Application No: FG/85/20/HH
Site Address: 18A Ocean Drive Ferring BN12 5GJ
Description of works: Garden outbuilding.

Thank you for your internet representation made on 23rd September 2020 which has been recorded as an objection with the comments as follows:

BLOCK PLAN 1:500 @ A4
PROPOSED OUTBUILDING

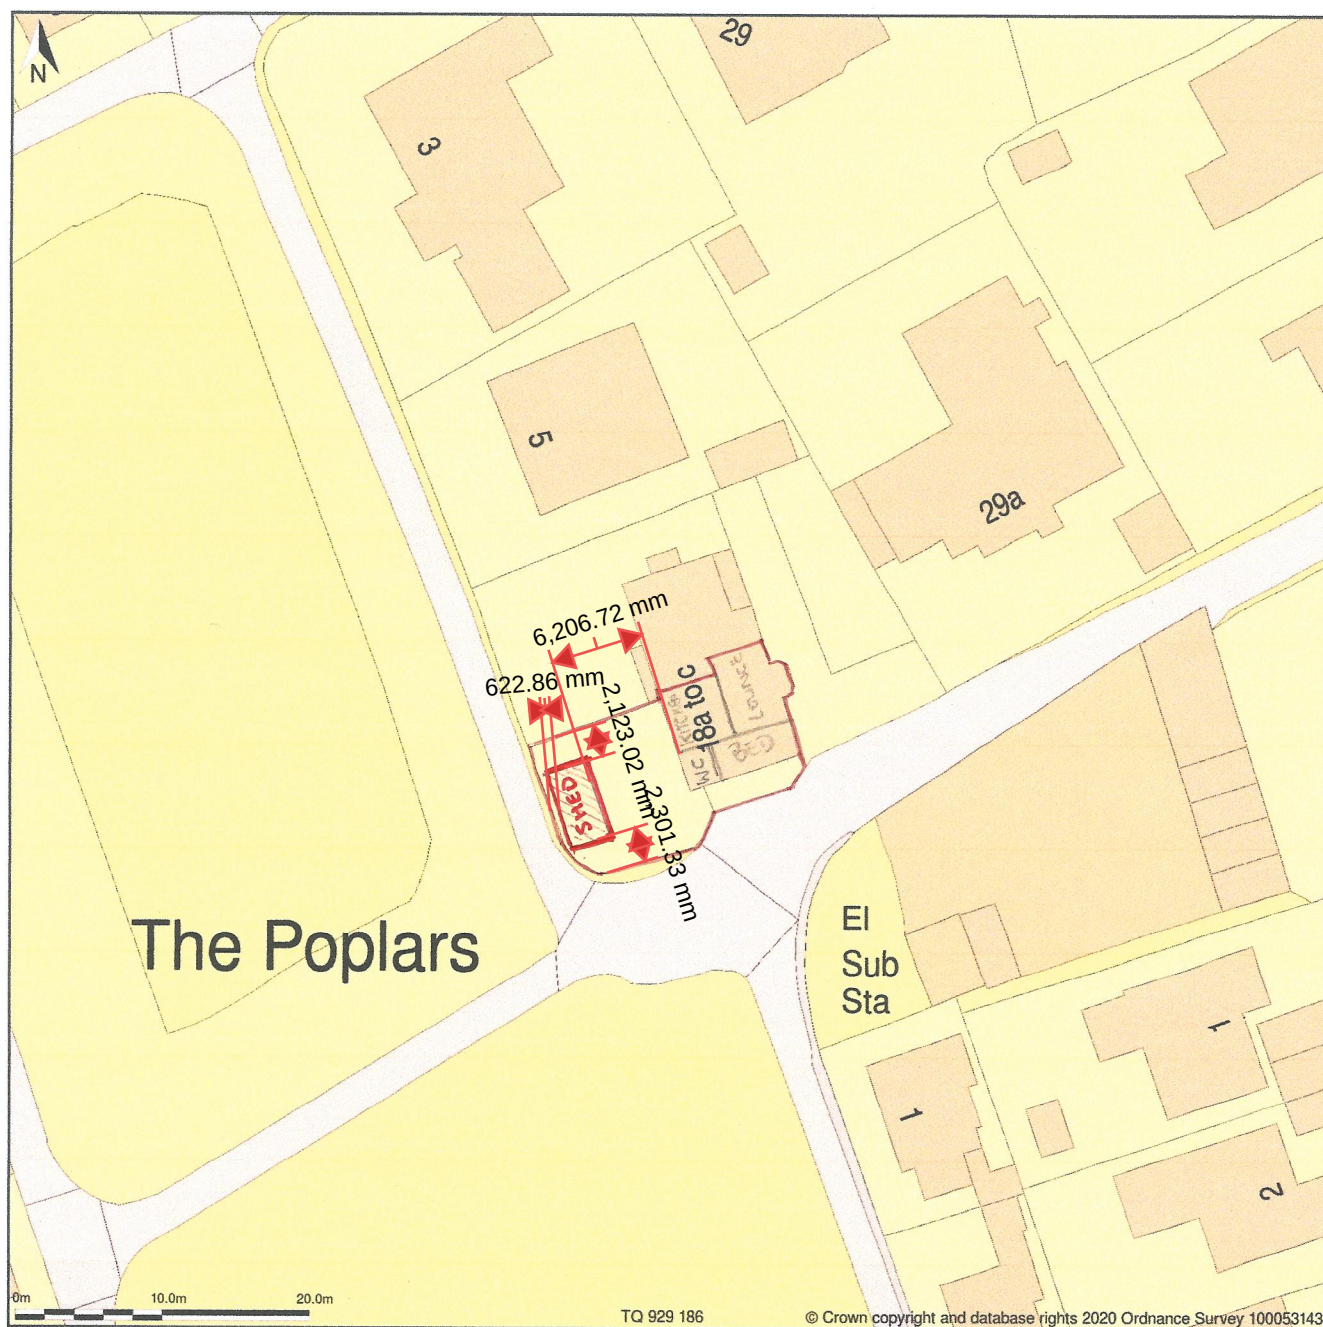
As a "garden shed", a building that takes up over 25 percent of the garden area seems rather unnecessary.

As a "summer house", a building that faces North East and with a view of the back of the house just 5 meters away, seems pointless, especially given the parkland view directly behind the property.

At 2.5m tall, and 5.5m long, I think this would look unsightly to the neighbours and detrimental to the parkland setting.

If this structure is truly to be a garden shed then a reduction in height to 1.8m (and kept below the fence line) should be imposed and acceptable to the applicant.
